Application No: EP/67/20/PL
Site Address: Land adjacent to 45 The Ridings East Preston BN16 2TW
Description of works: 1 No. detached house & formation of associated new access.

Thank you for your internet representation made on 18th June 2020 which has been recorded as an objection with the comments as follows:

DWG NO
935/PO1

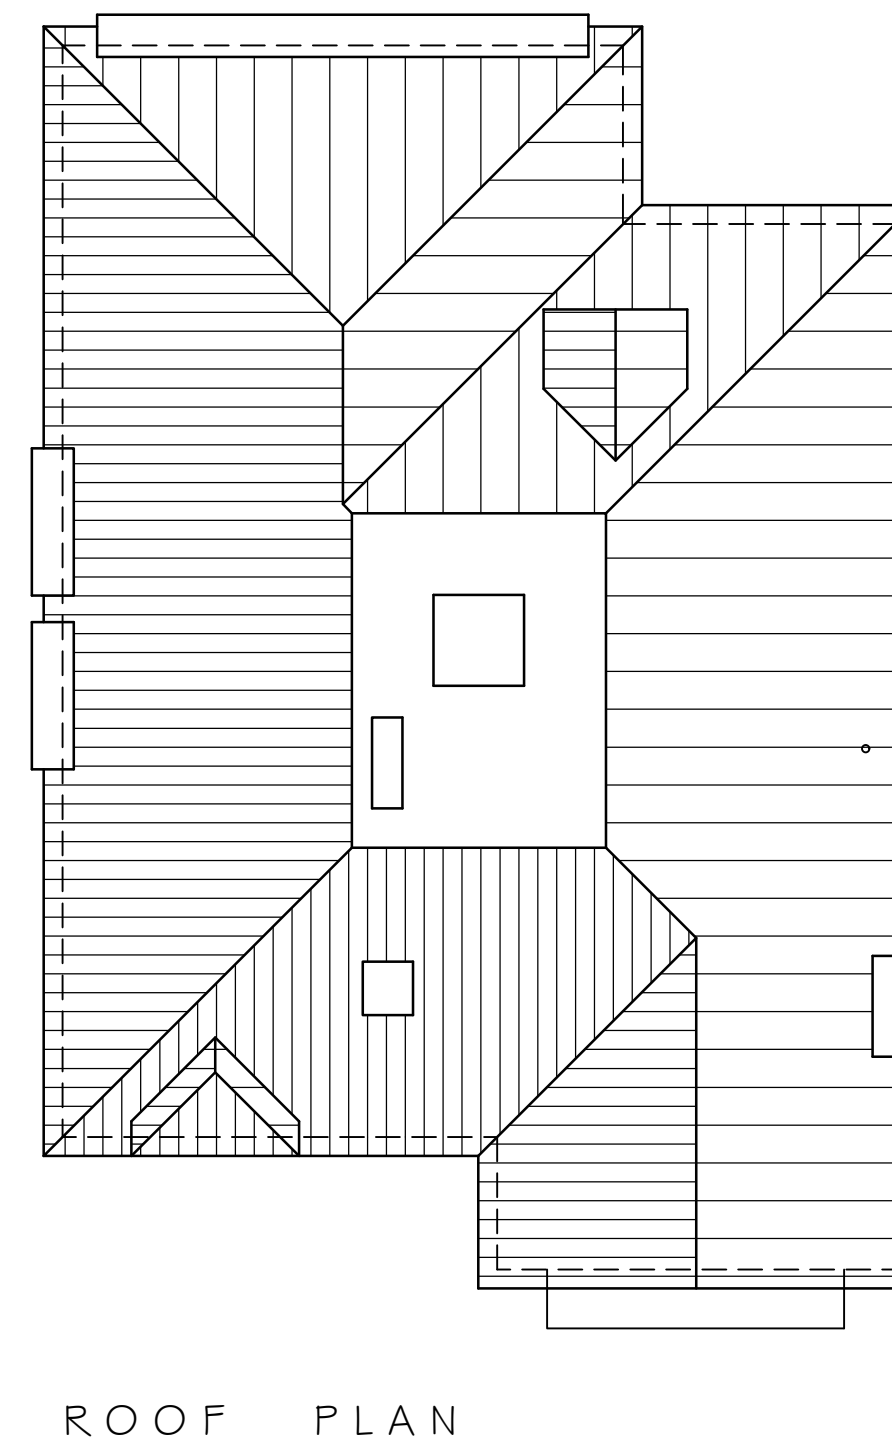
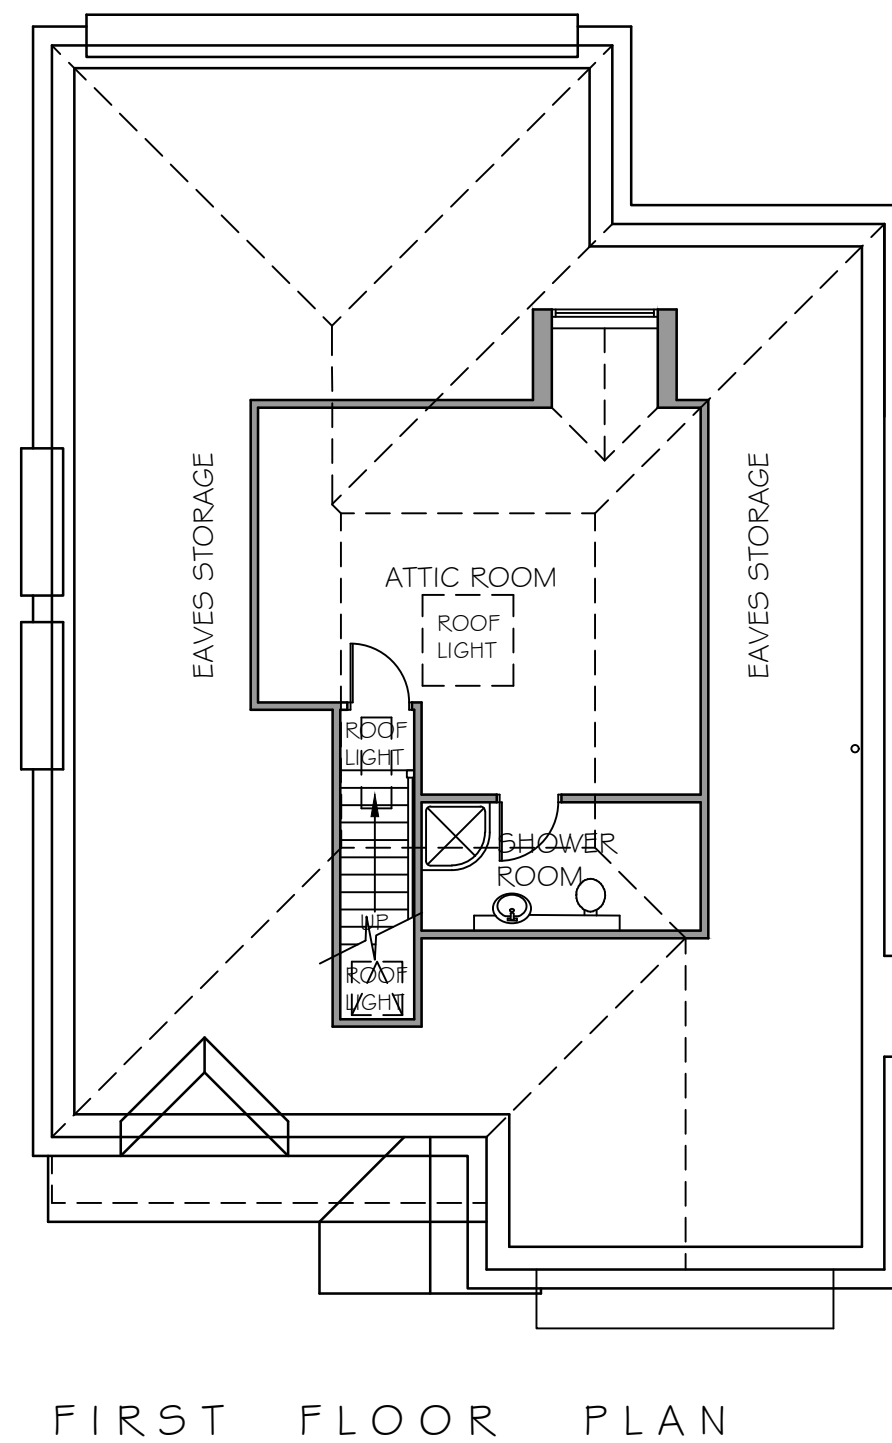
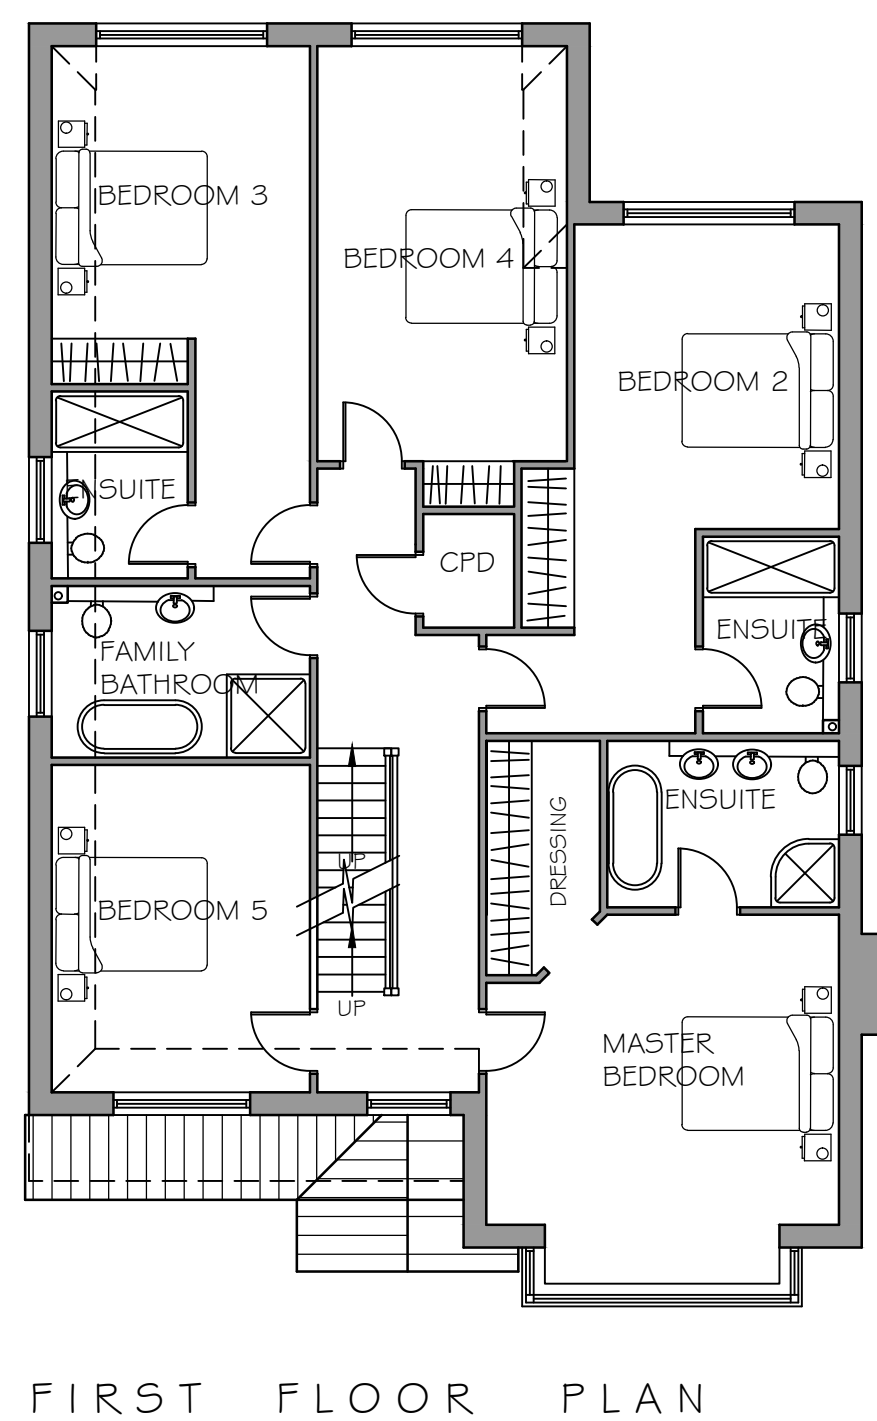
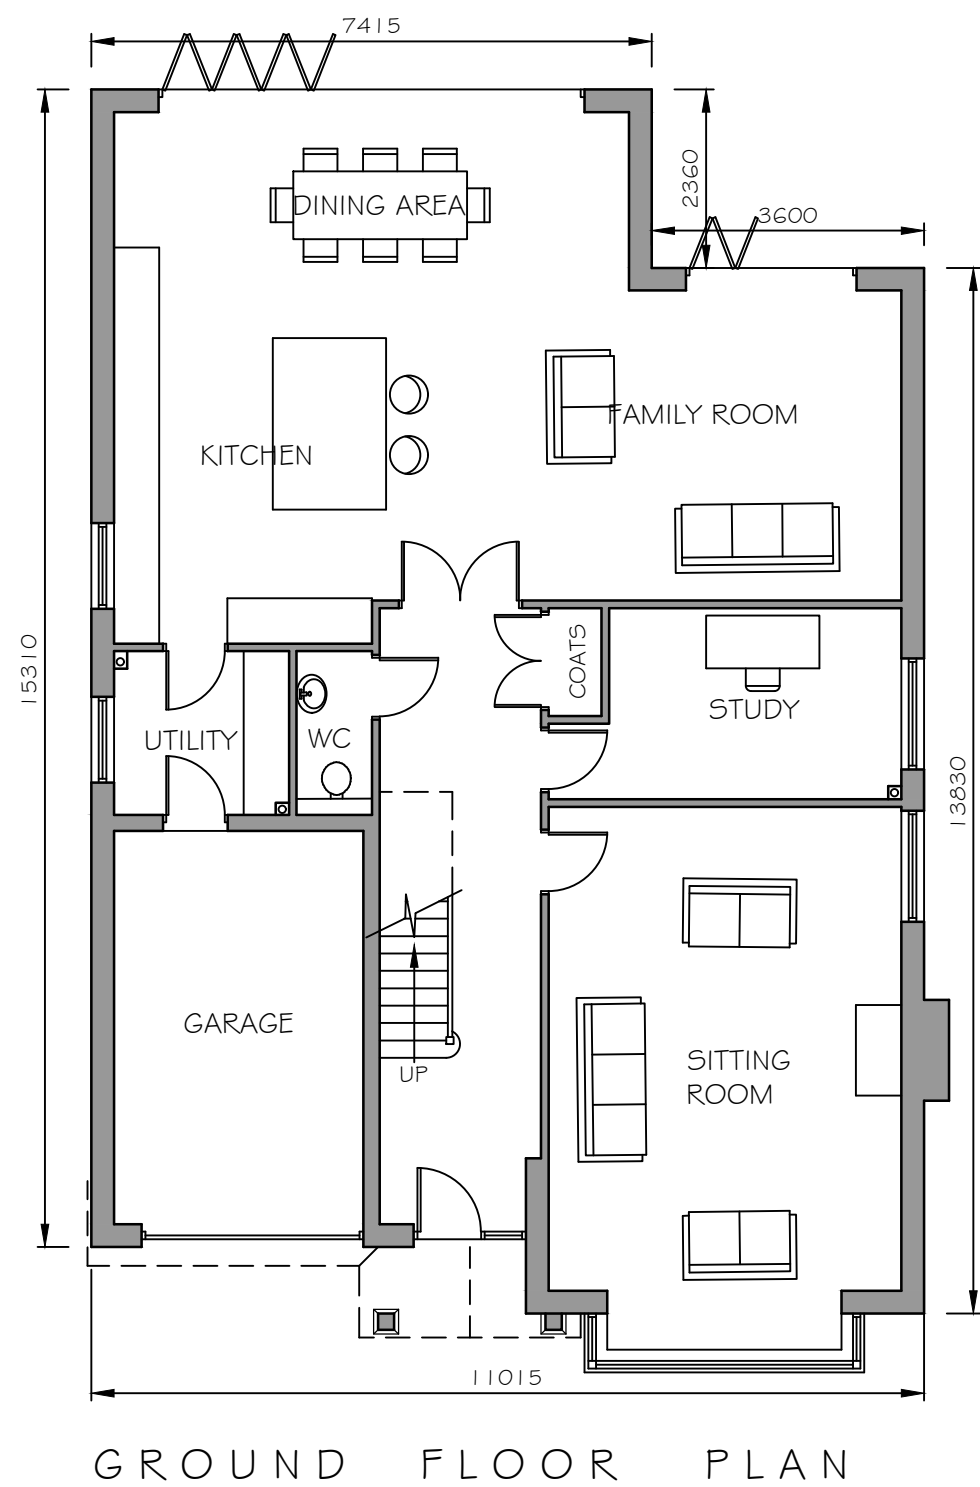
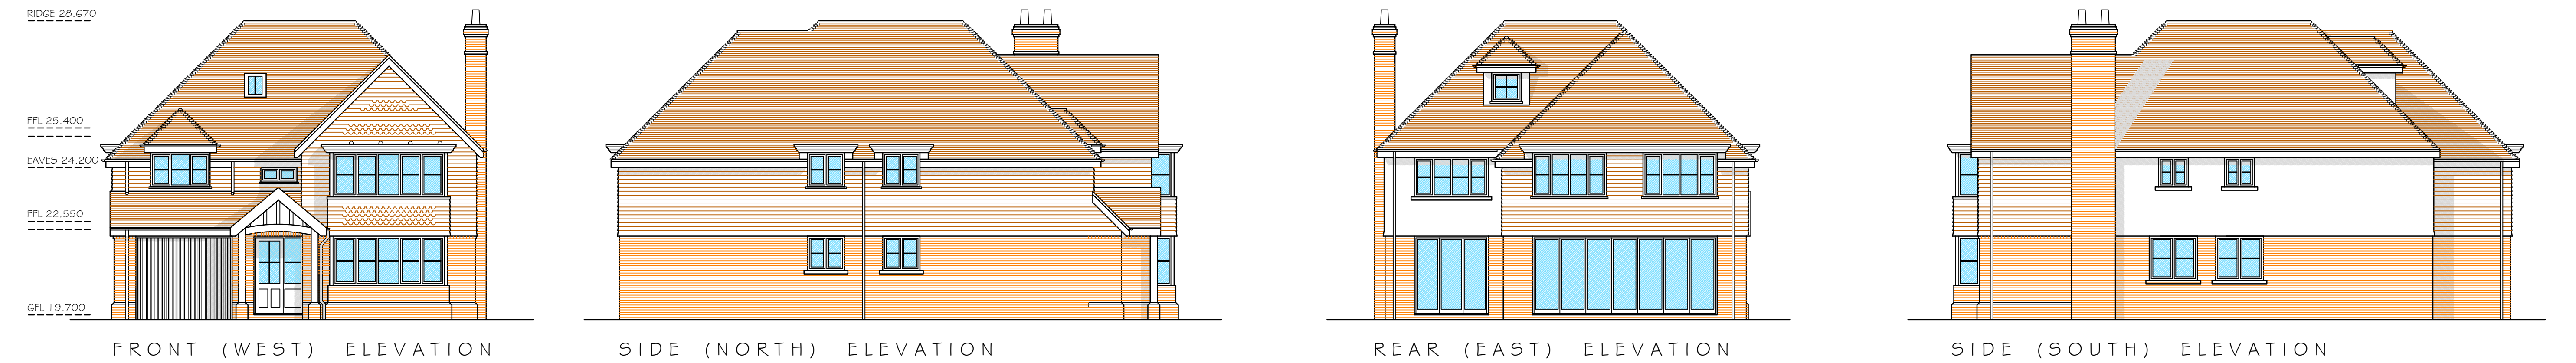
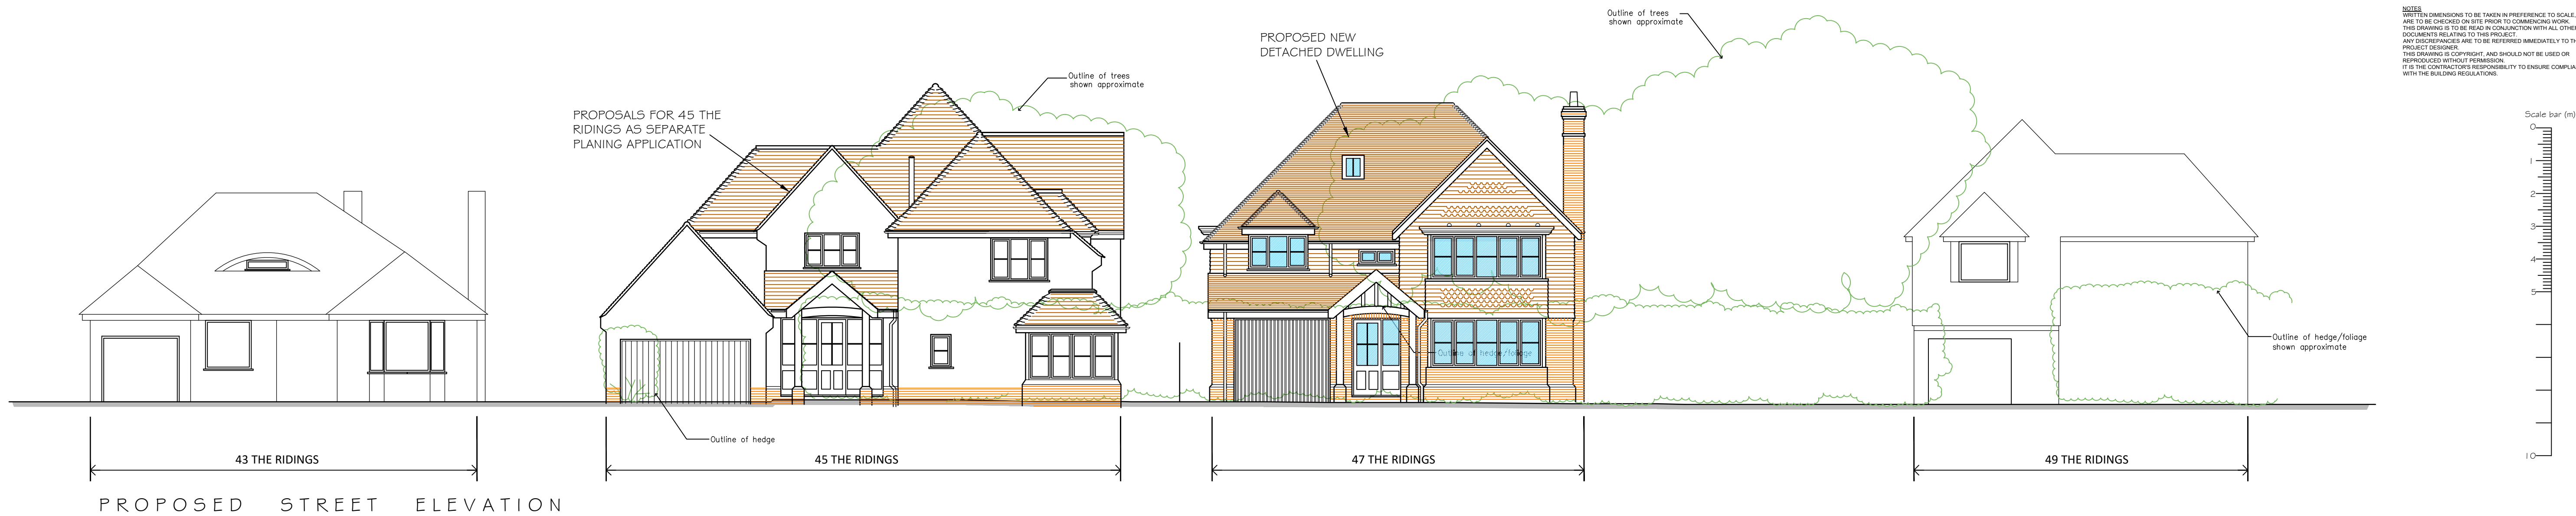
The proposed house is vastly oversized, I see a very small garage with limited drive space so I assume as parking on the road is not permitted, it would be owner occupied by a couple with one car and a bicycle each.

The height of the house is far too high, compared to the adjacent properties and will completely overshadow the skyline and the homes around. There seems to be an admittance of the overall height of the building, just approximate reference to the existing trees and bushes.

I also totally object to the third storey window west facing as it will look directly into our home opposite at 38 The Ridings, a traditional thatched cottage with low level roofing.
